George Froehlich - Fwd: 14 Brook Lane

From: "Andy Jackson" <aj04005@gmail.com>
Date: March 27, 2015 at 3:03:28 PM EDT
To: "Thompson Johnson Woodworks" <heather@tjwhome.com>
Subject: 14 Brook Lane

<!--[if !supportLists]-->?? <!--[endif]-->Yesterday I reviewed the framing repairs at 14 Brook Lane. I understand that TJW has corrected a problem that resulted from the past installation of a dormer in which the roof collar ties were cut, resulting in the rafter thrust pushing the wall studs and top plate in the kitchen area out of plumb.

### Proposed Demolition and Framing

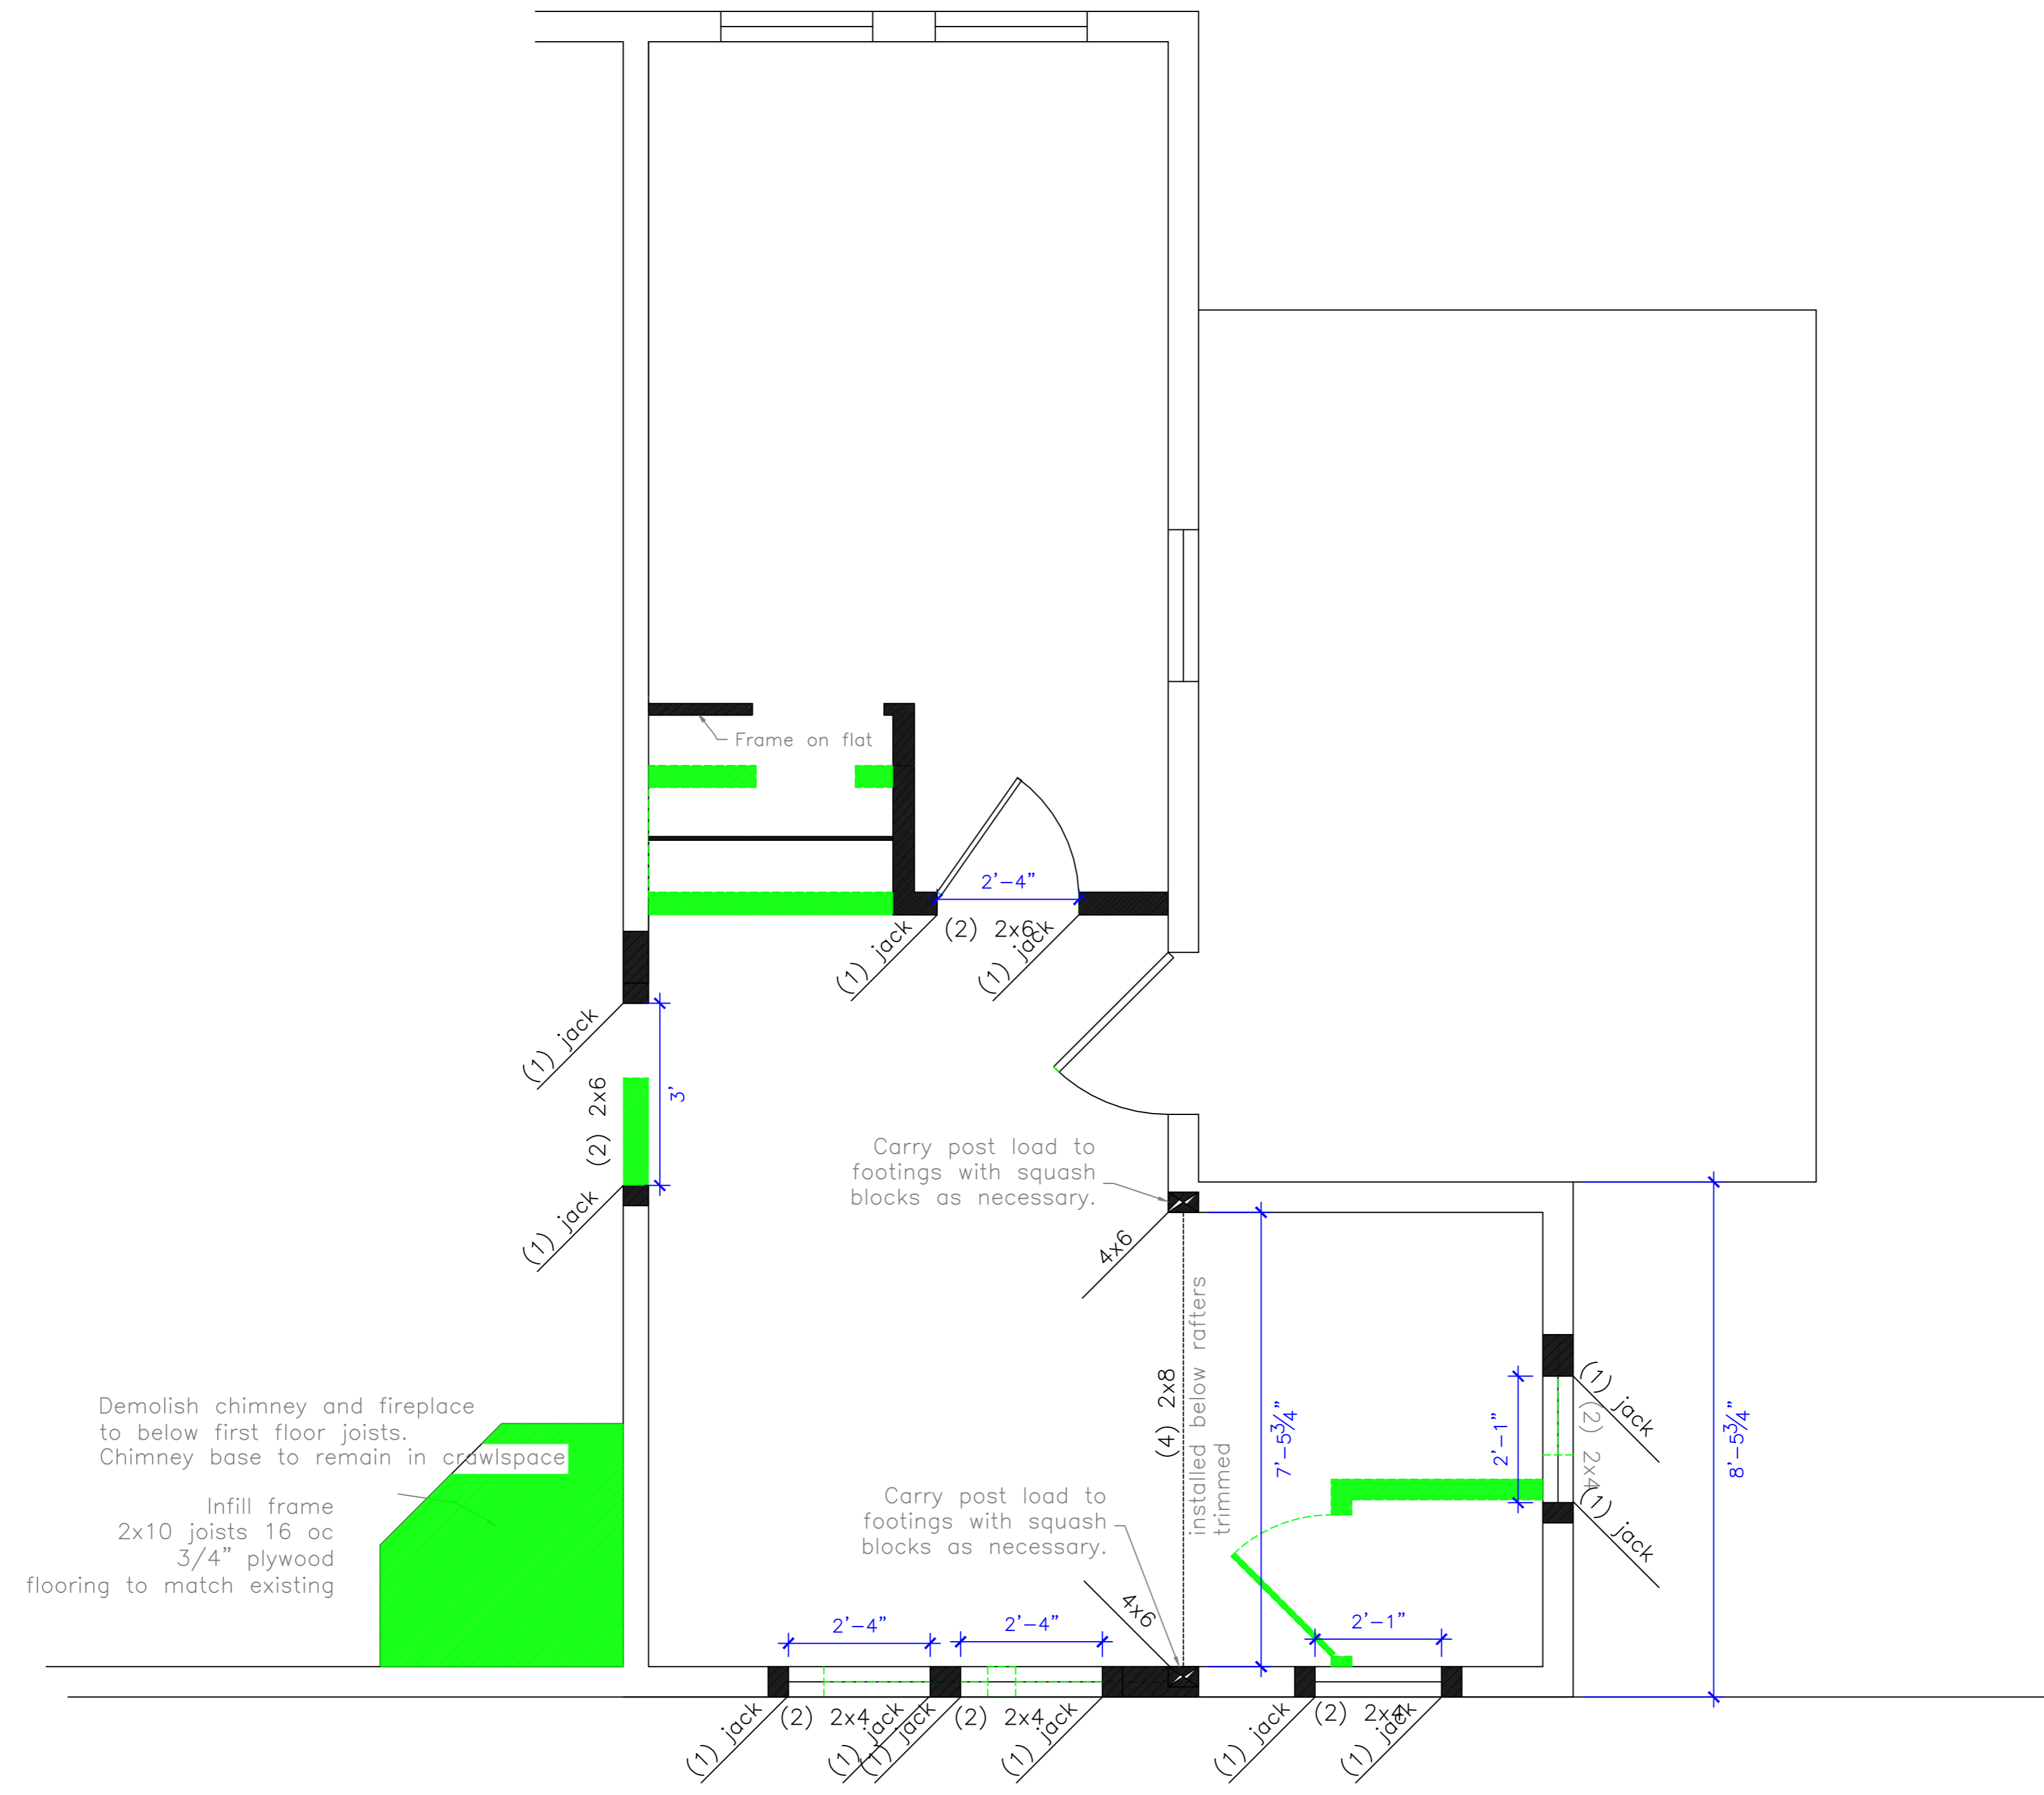
<!--[if !supportLists]-->?? <!--[endif]-->The solution developed by the carpenter is to install new LVL studs from the floor level, balloon framed past the second floor joists, to connect to the bottom of the existing rafters. This creates a new load path for the rafter thrust by connecting the bottom of the rafter with (3) or more 16d nails to the wall stud, which is connected directly to the floor joist with (3) or more 16d nails. The LVL stud bears on an existing floor beam below. This work is consistent with the rafter / ceiling joist nailing requirements specified in IRC table R802.5.1(9) for 50 lb/ft² ground snow load, up to 28" rafter spacing, and a 12:12 pitch.
